**BCA ASSESSMENT REPORT -
SCHEMATIC DESIGN**

**PROJECT: Goulburn Hospital & Health
Services Redevelopment**

PREPARED FOR: TSA Management

Date: 27 September 2017

DESCRIPTION
PROPOSED PRECINCT
PLAN - LOWER
GROUND FLOOR

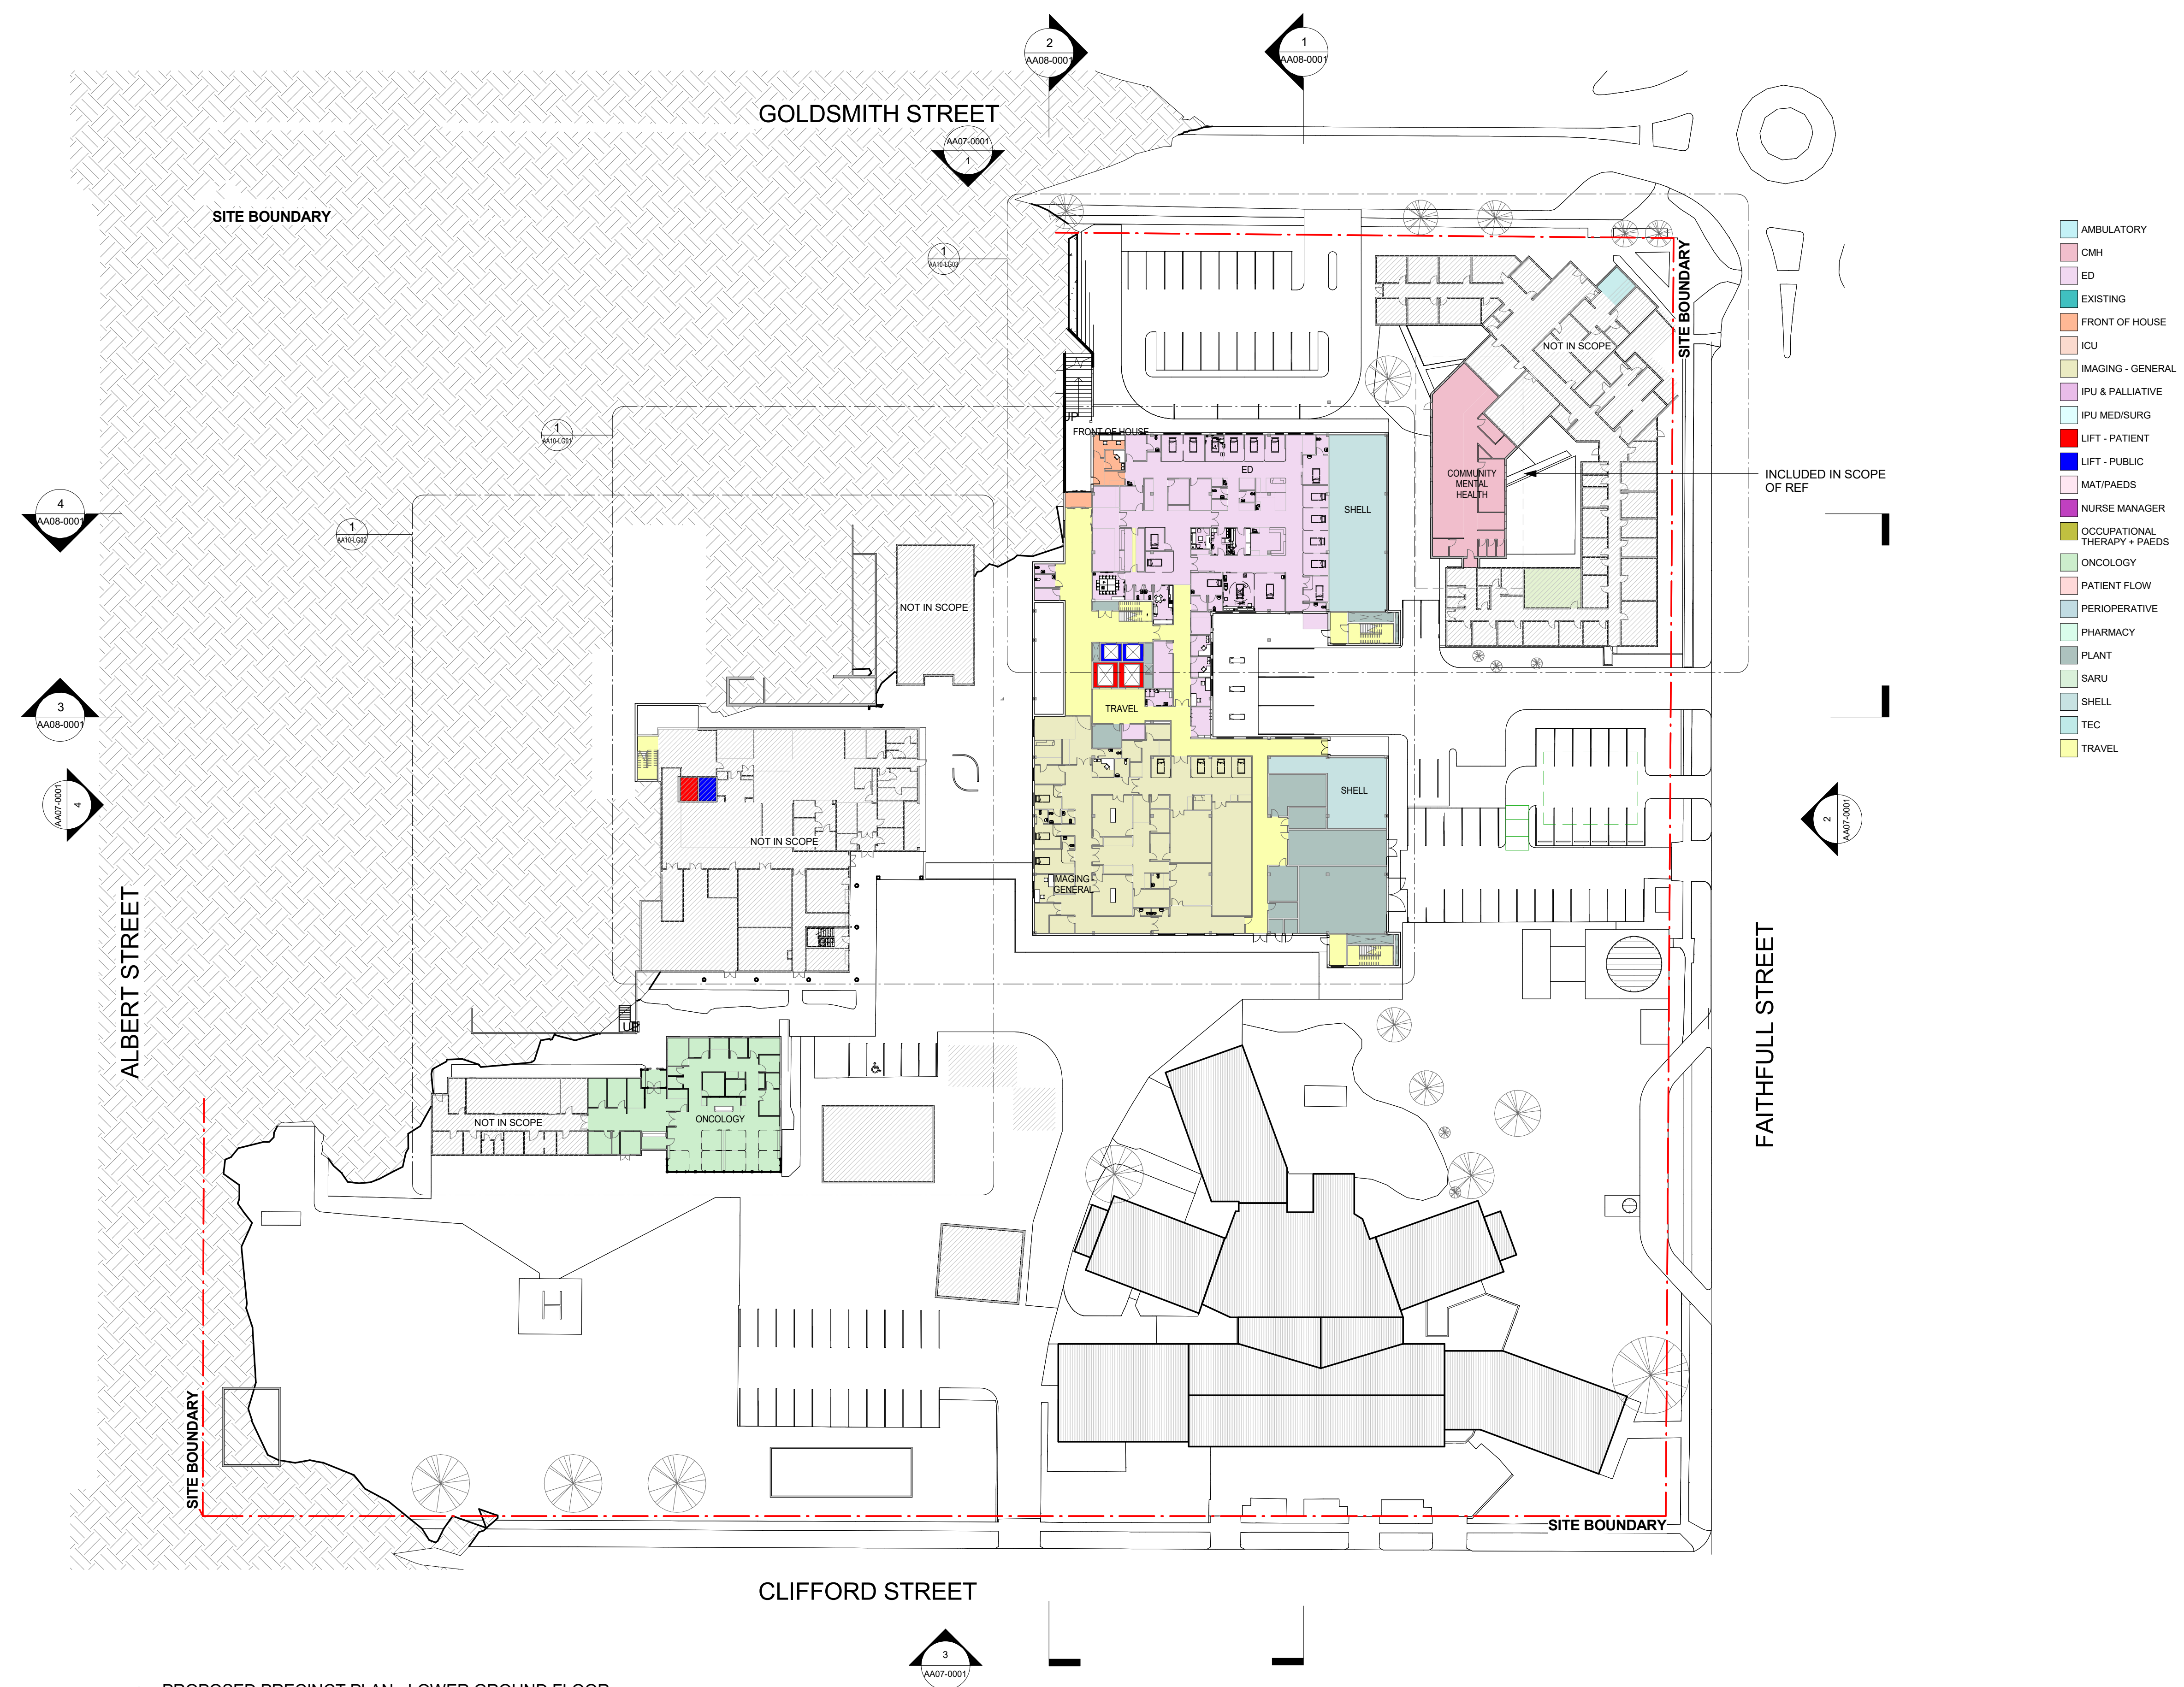
5.	D1.2	The central Plant room on Level 3 requires access to the fire stairs. An additional exit to open space is required to southern side lower ground floor medical imaging. An additional doorway is required from the MRI scanning room on lower ground, to provide access to point of choice. Confirmation required if egress for pathology is provided by stairway. The new link is “enclosing” the existing pathology building therefore egress from this building must be considered.

PROJECT
GOULBURN
HOSPITAL &
HOSPITAL SERVICES
REDEVELOPMENT
DESCRIPTION
PROPOSED PRECINCT
PLAN - FIRST FLOOR

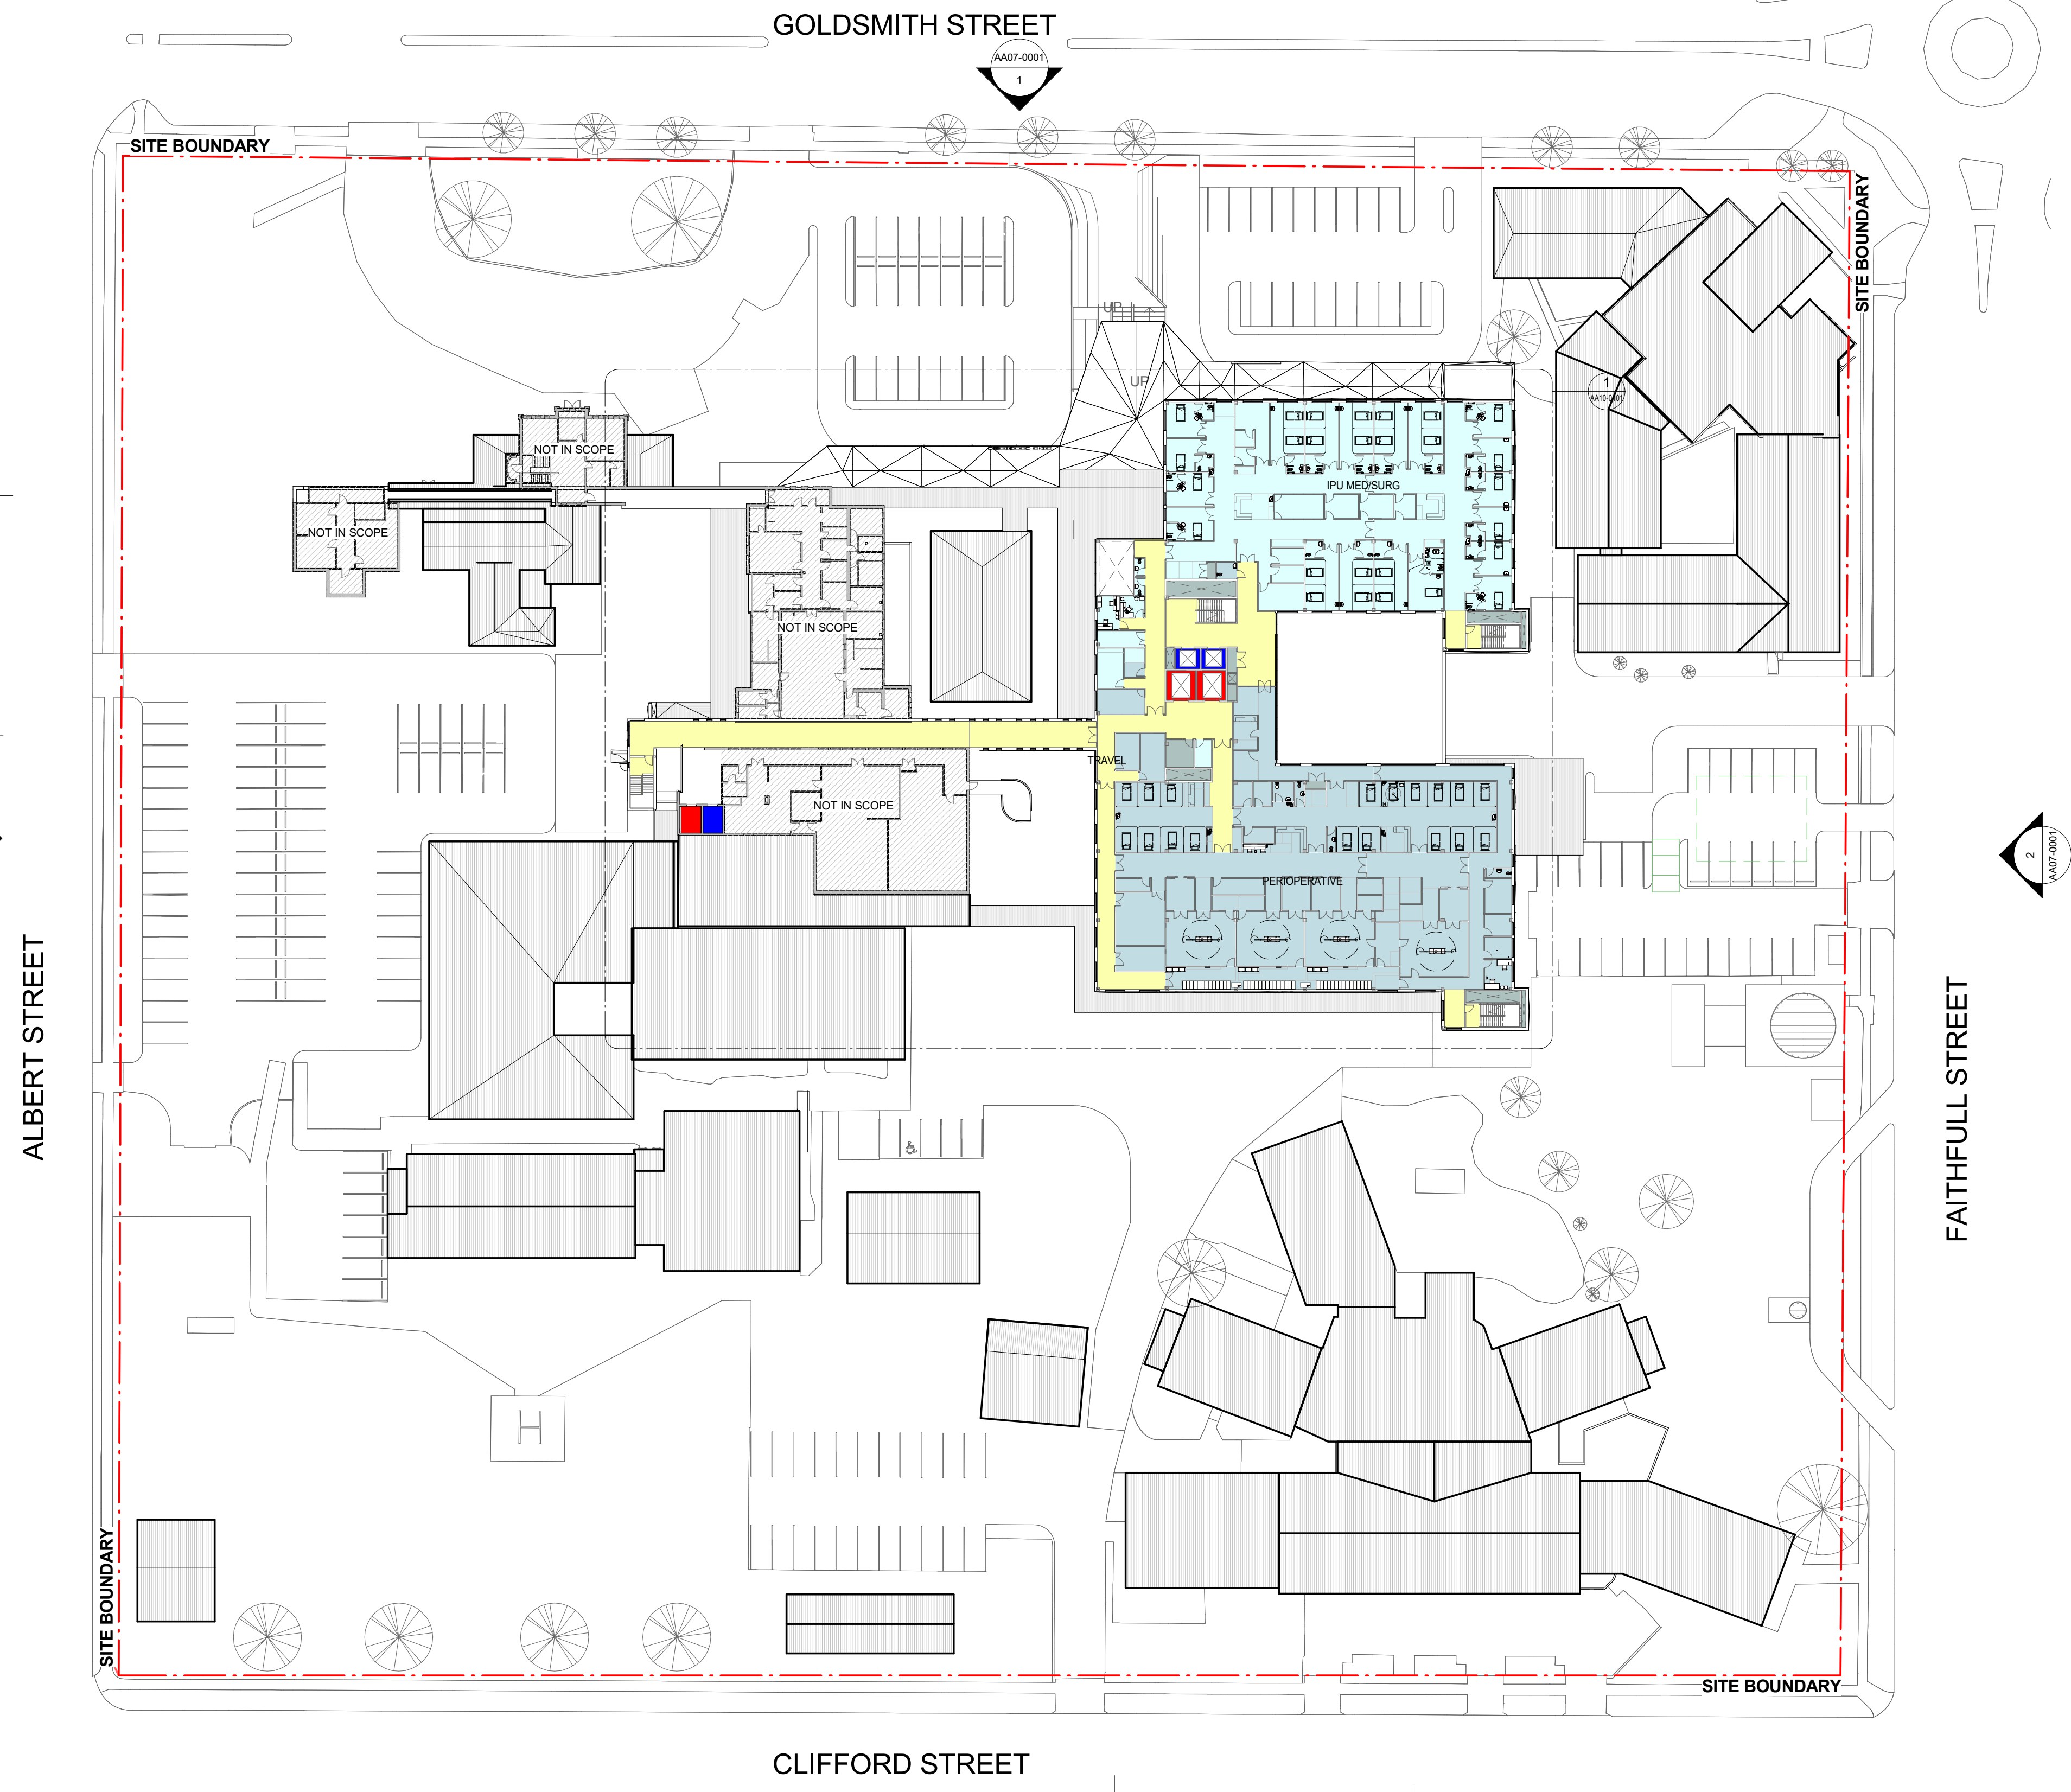
4.	Spec C1.1	Further specific details are required on the use and extent of Aluminium Composite Panels. Further information is required regarding the structure of the pedestrian link bridge on level 1 from the new acute building to existing hospital building. The bridge is required to be constructed with FRL of 2hrs or addressed in the fire engineered performance solution.

BCA (DtS) Clause		Description
1.	C1.1	Fire rating of steel structure of the link walkway between new acute building and existing buildings on Level 1.
2.	C2.5	<p>In regards to the new acute building;</p> <ul style="list-style-type: none"> + Smoke compartment size are to be addressed through fire engineered performance solution. Max. smoke compartment size is 560m². + We recommend providing wall that are noted as smoke wall to be upgraded to 2hr fire and smoke walls. This assists with horizontal evacuation and travel distances. + The fire compartment on ground floor SARU is to be divided further, no smoke compartment to exceed greater than approx. 560m².
